**ADC Planning Consultation
Conservation/Design Officer Response**

Application Number	A/155/17/OUT
Address	Avenals Farm Water Lane Angmering BN16 4EP
Description	3No. dwellings. This application affects the setting of a Listed Building & is a Departure from the Development Plan.
Case Officer	Mr D Easton
Date	22 November 2017

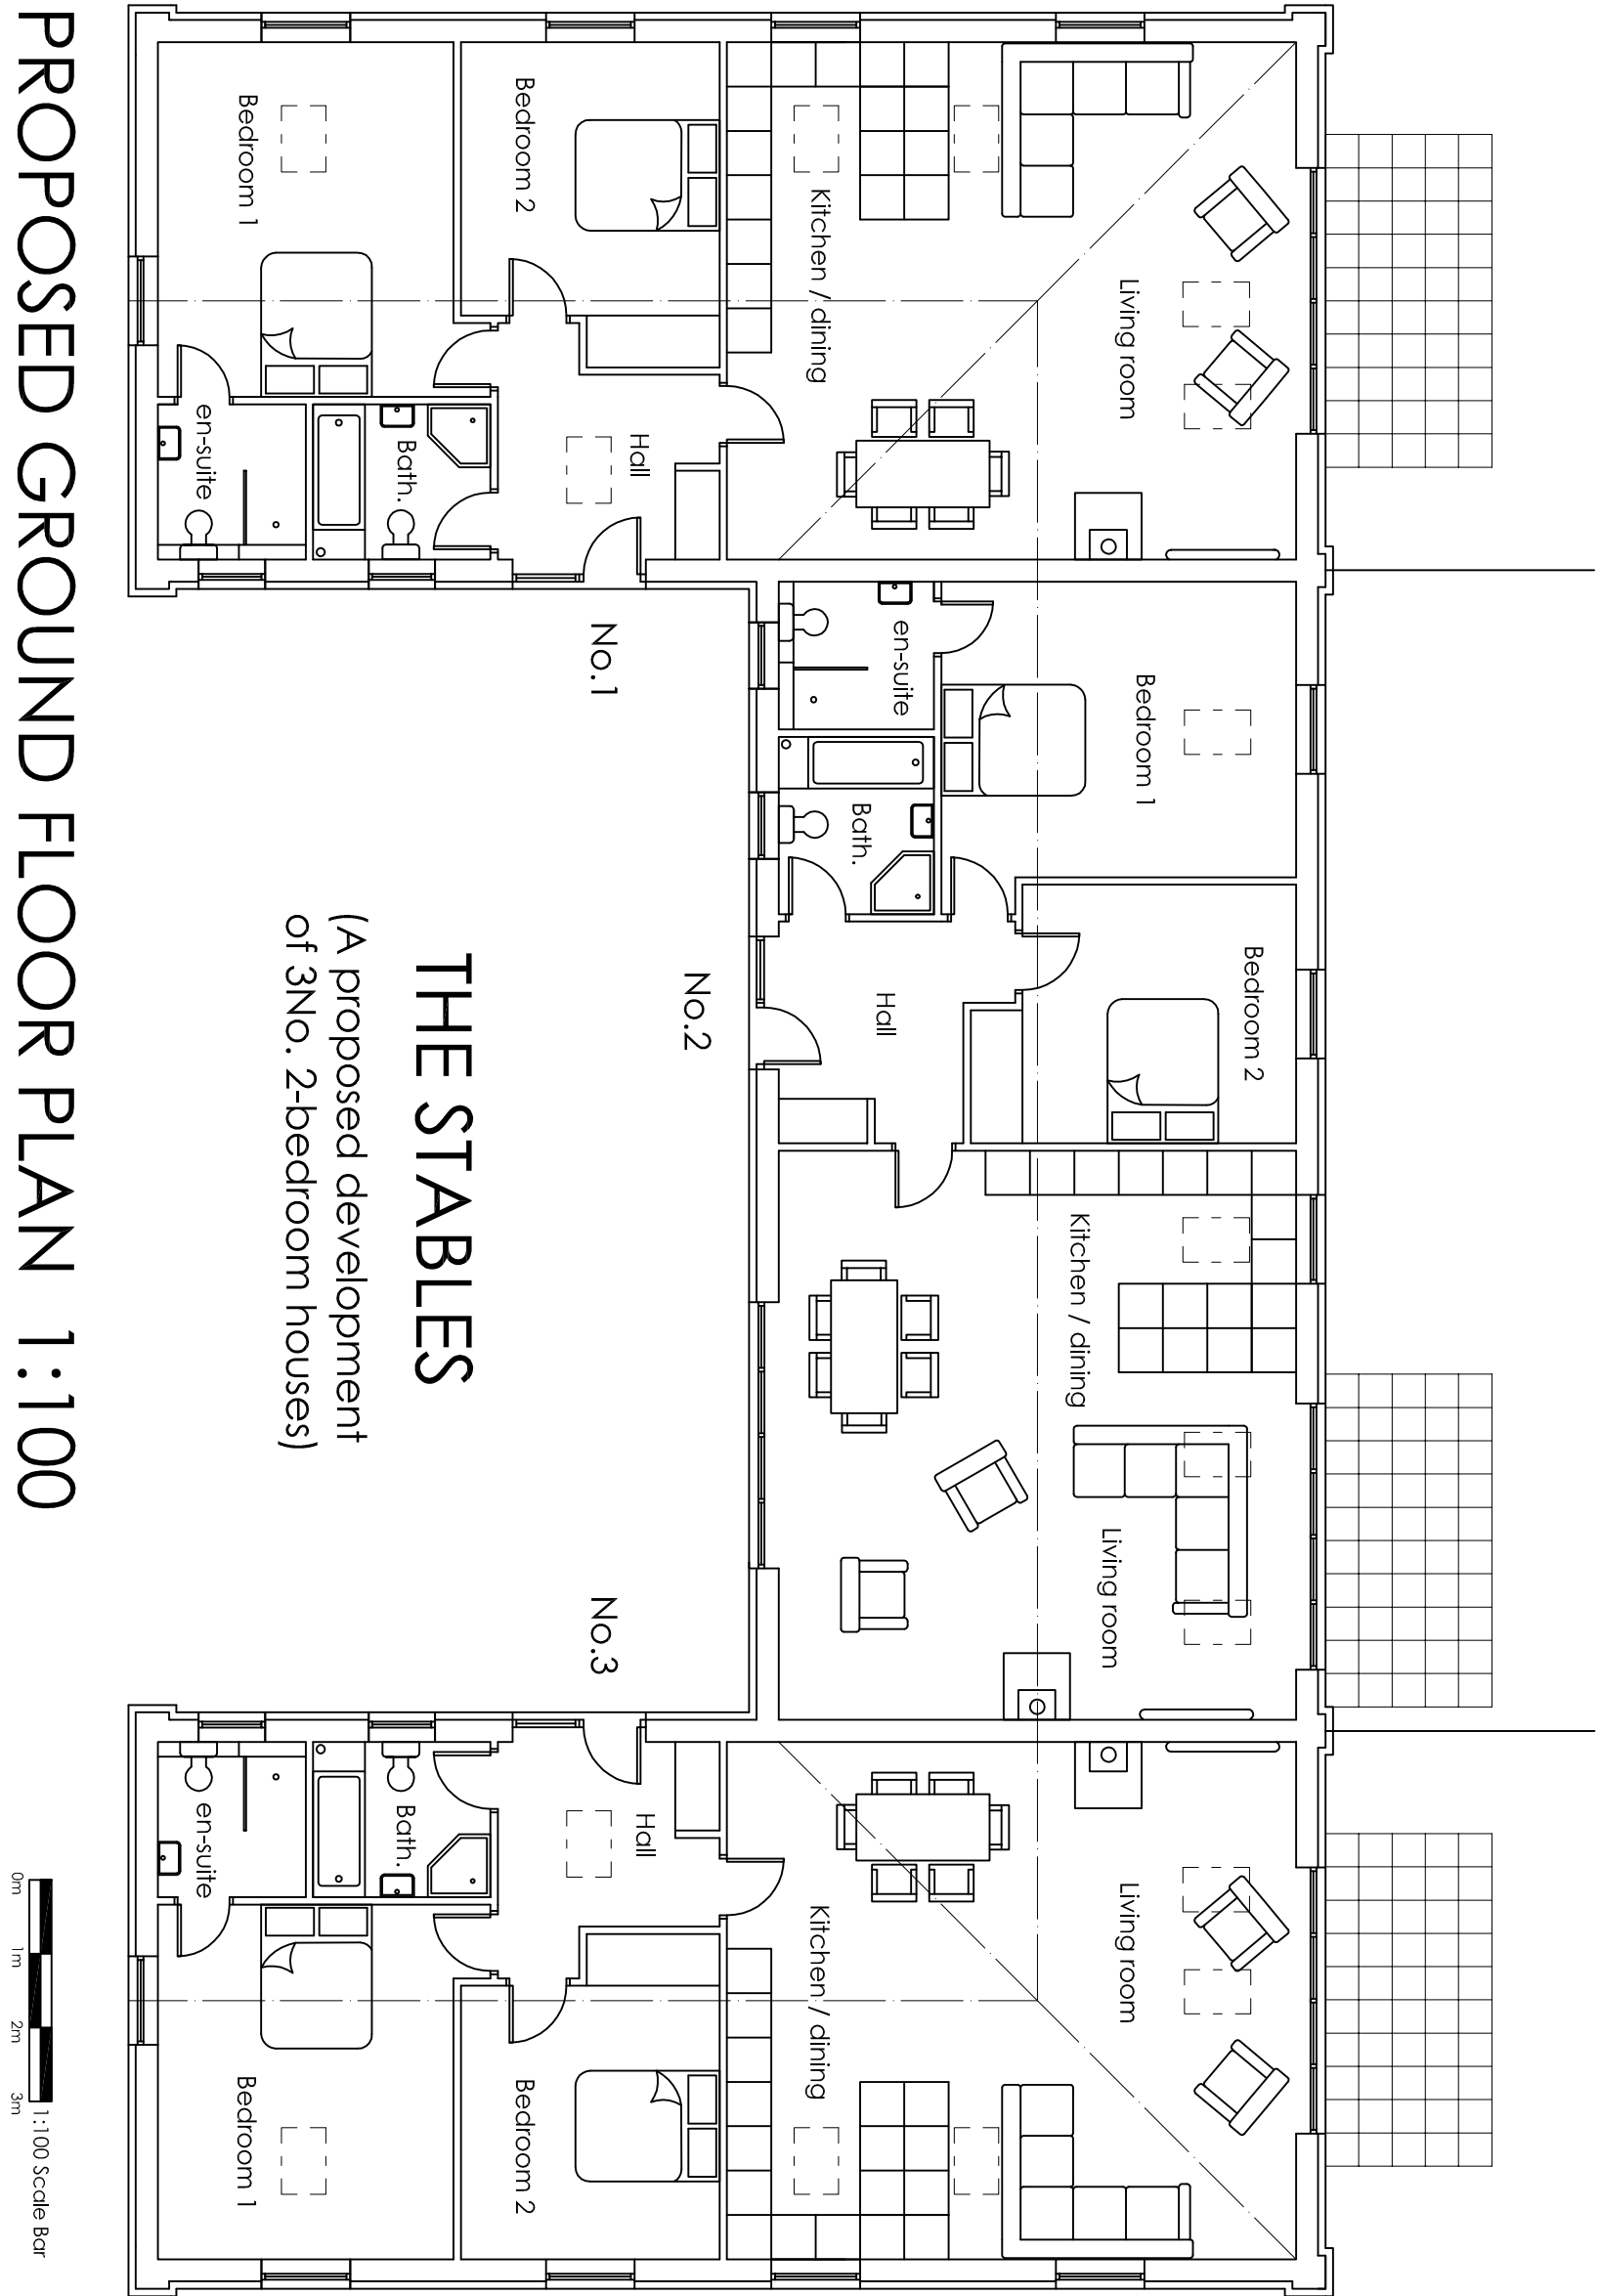
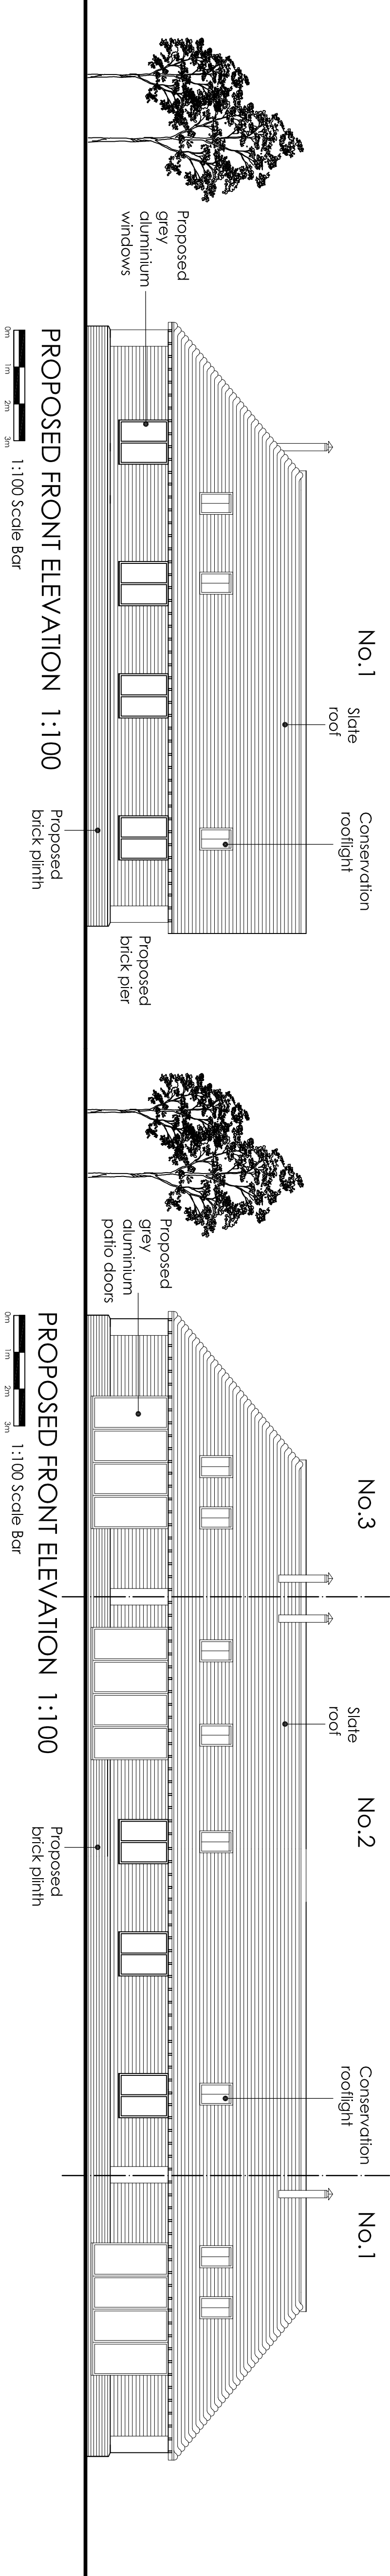
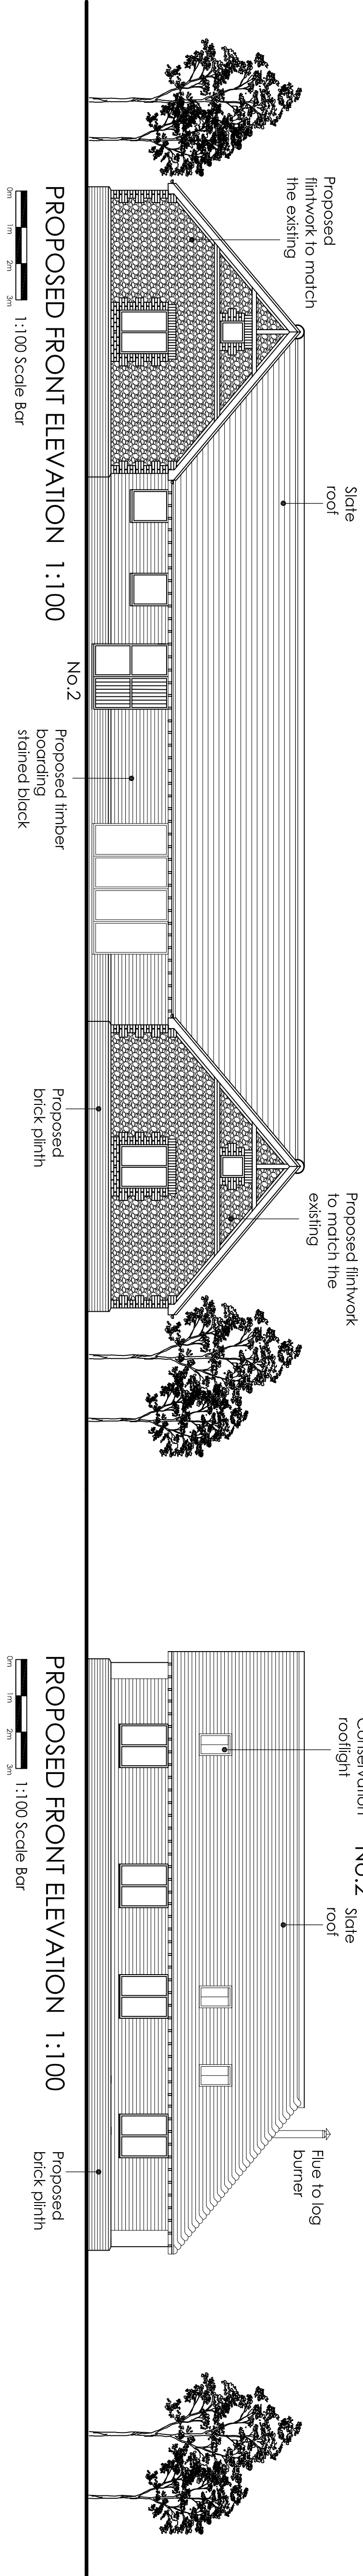
The proposal seems incongruous to the agricultural setting in terms of the number of rooflights, and large expanse of communal courtyard and hard landscaping for parking for 7no cars, cycle storage and communal bin store. The proposed material palette of flintwork/brick/slate roof and black stained timber are considered suitable choices and would relate well to the existing converted barn. The large areas of glazing of PCA to grey colour, rooflights and large patio doors are considered out of keeping with a rural/agricultural setting.

PROPOSED SITE PLAN 1:200

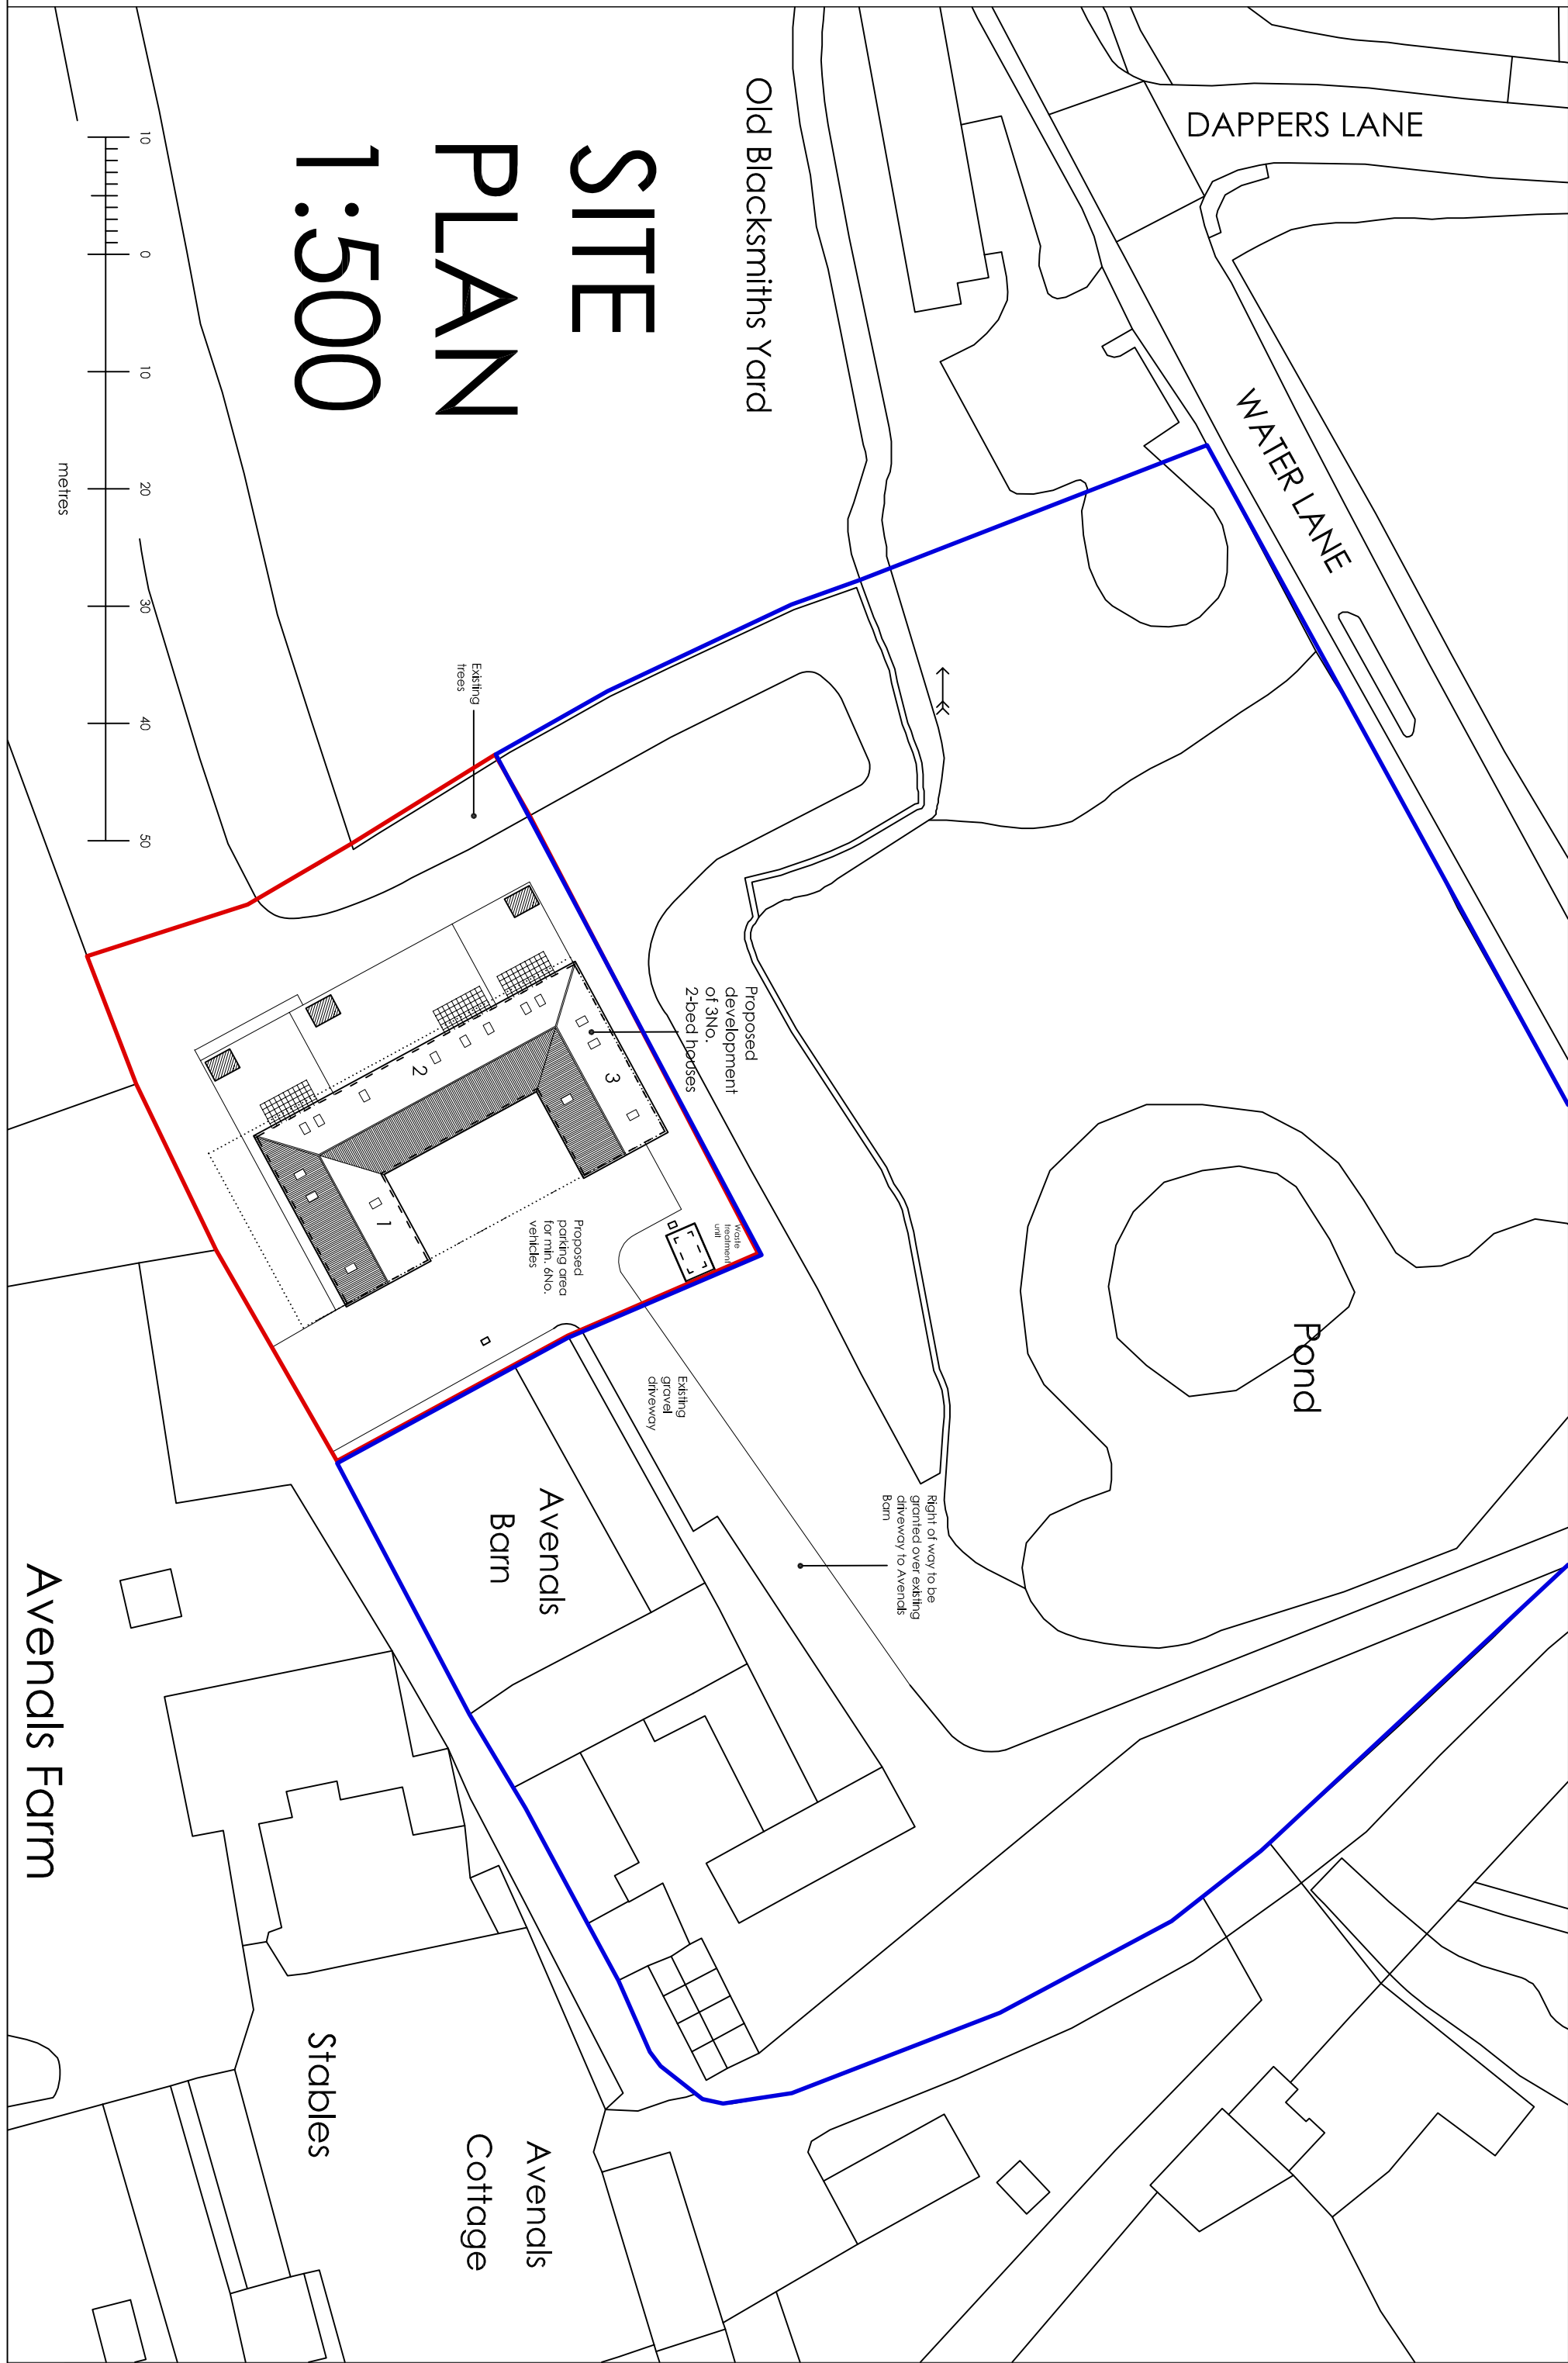
The submitted proposal is for 3no dwellings in a courtyard type setting, with landscaping.
